#0692 - EL PASO COUNTY, CO
 6809 SPACE VILLAGE AVENUE
SITE DEVELOPMENT PLAN

DATE: 09/08/2017
 SHEET NUMBER: C1.1
 1 OF 1

Markup Summary

C2.1  
5 OF 7

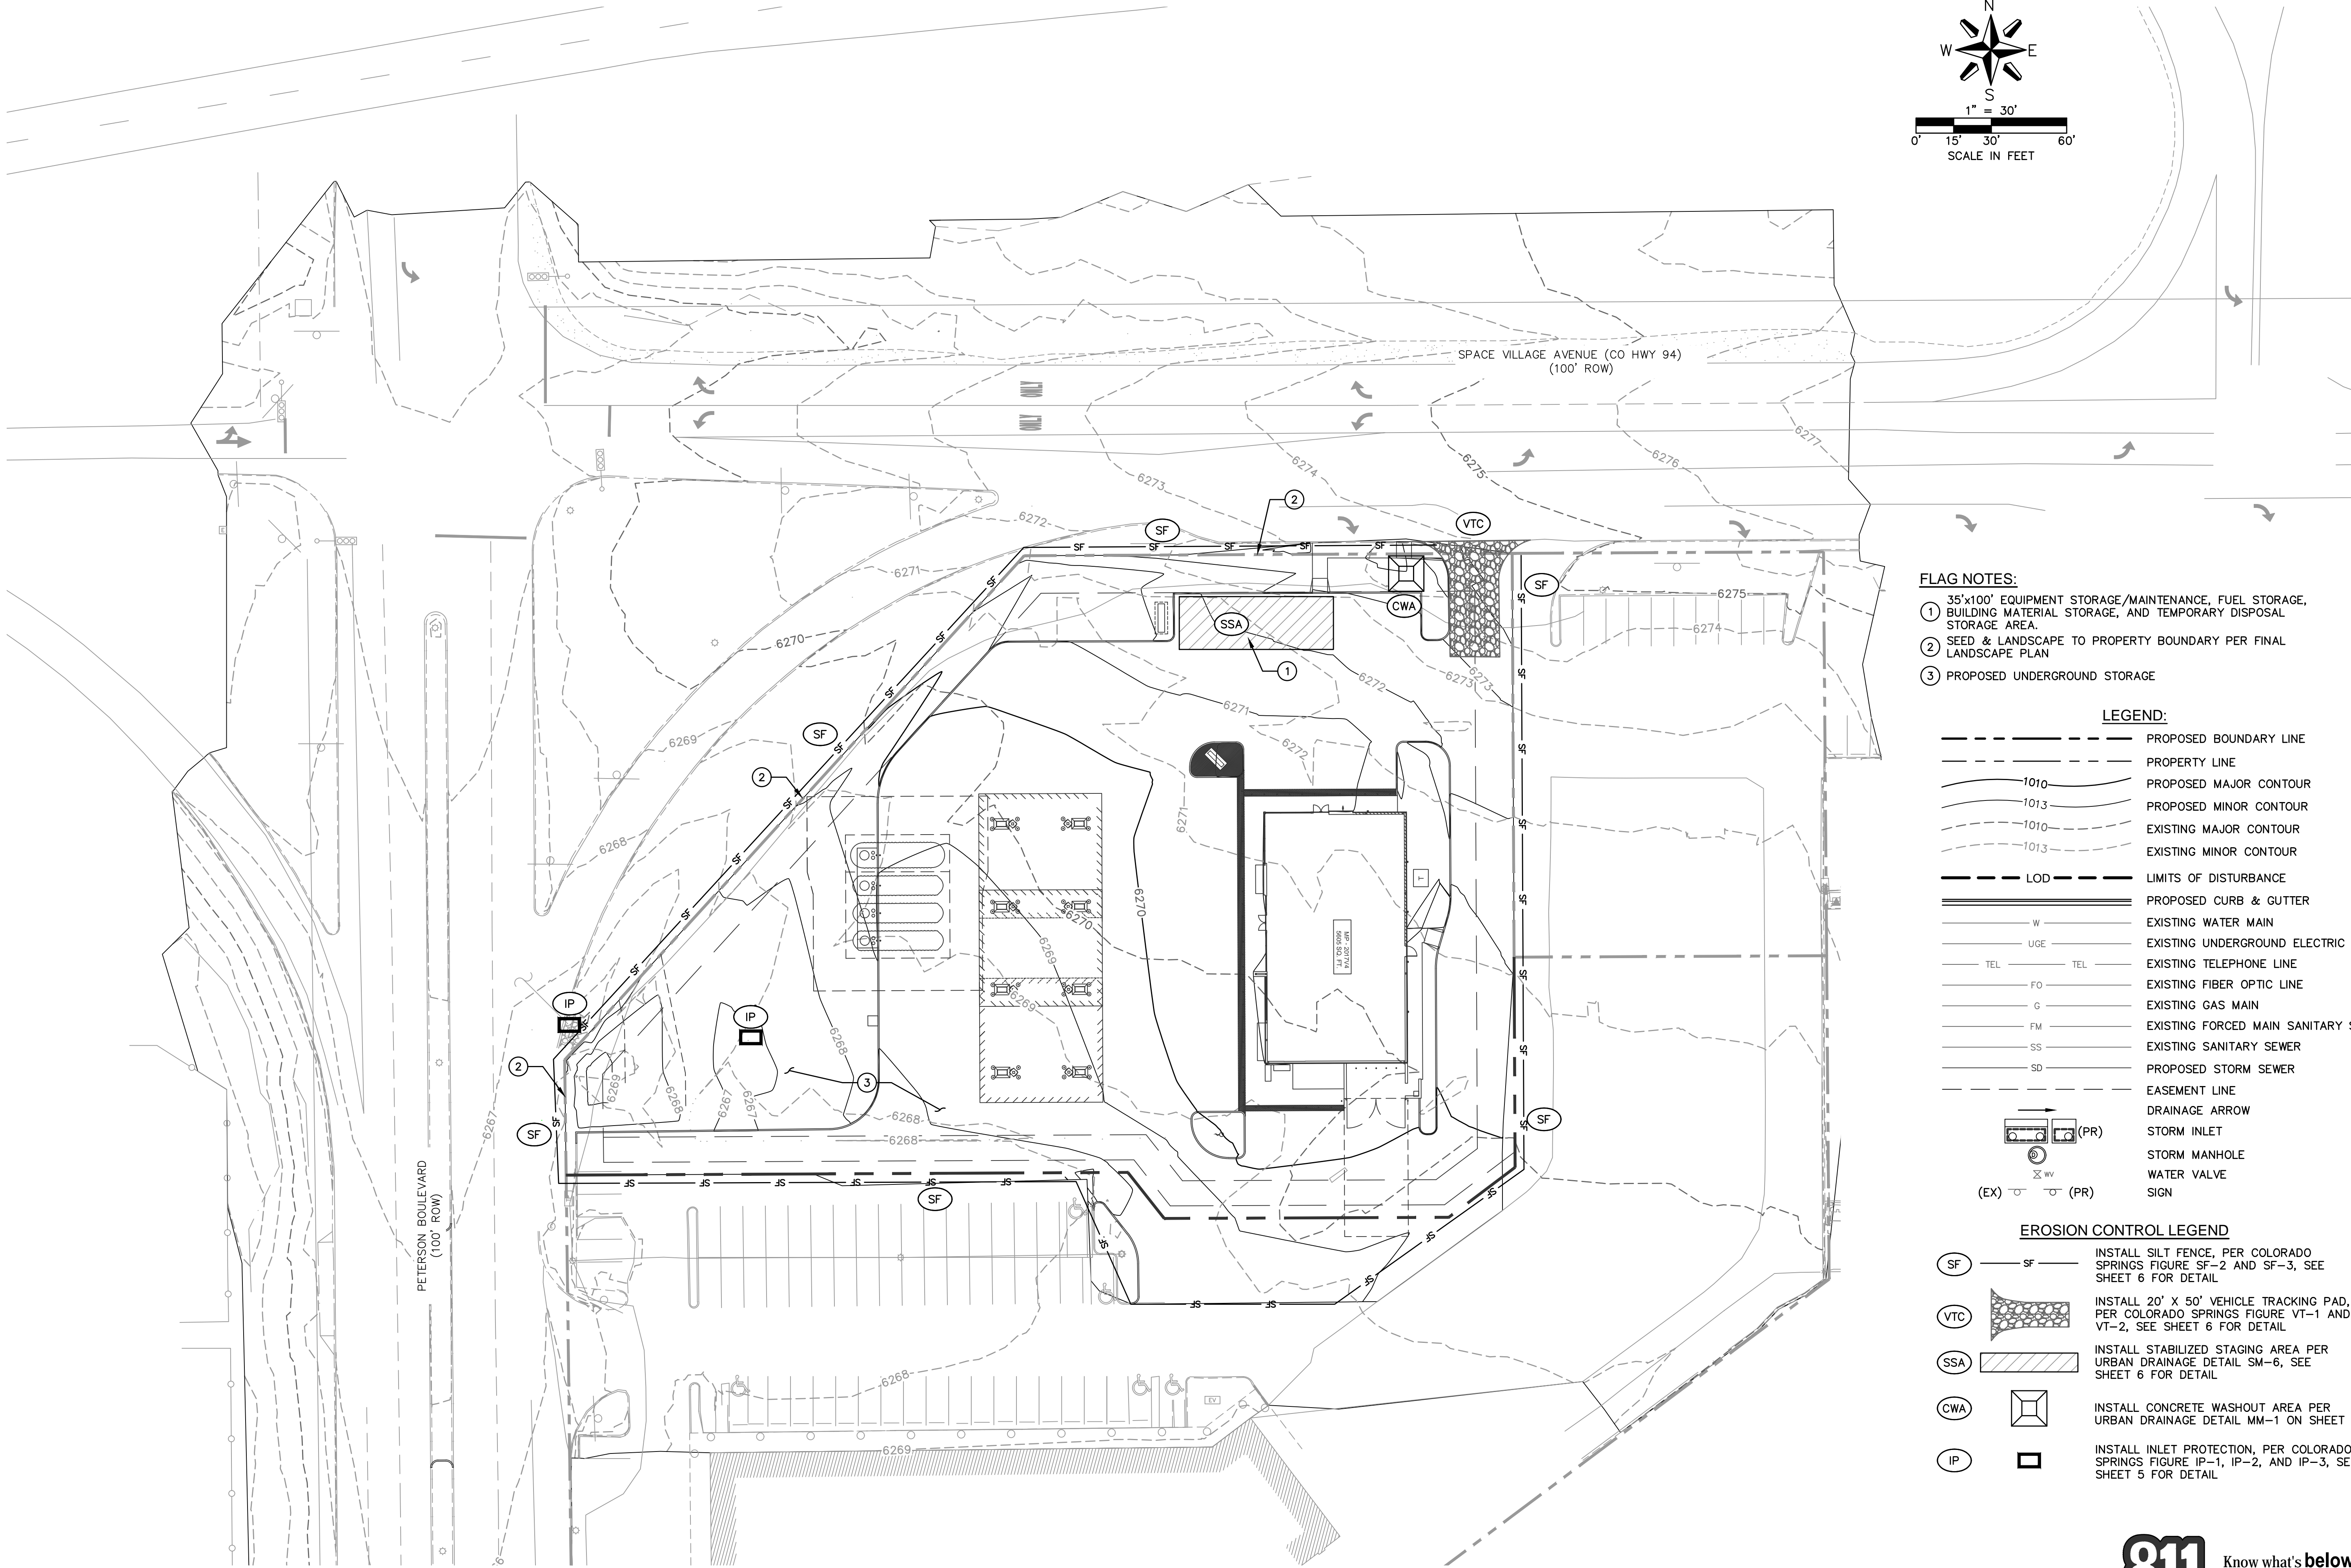
Contact CDOT and the City of Colorado Springs regarding their submittal requirements for the proposed improvements to Peterson Road and US-24 off-ramps.

All the offsite improvements must be approved prior to or concurrent with the site plan.

Submit street construction plans with the site plan application for the proposed modification to Space Village Ave. Include the attached standard El Paso County Notes on the construction plans.

Add "Refer to the Grading and Erosion Control Plan."

Approval from CODT, Colorado Springs required

Reference the specific County Ramp details.

Include the detail for this item.

Callout the curb cut and note the width.

Identify the sidewalk width

Show the outline of the underground detention. Provide verification from the utility companies that they have no issues with having the detention facility within their easement.

Replace the entire crossspan and the pedestrian ramp at the east side of the intersection.

Revise the curb return radius. See ECM Table 2-31

Place the section of sidewalk that is outside the ROW within a public improvement easement.
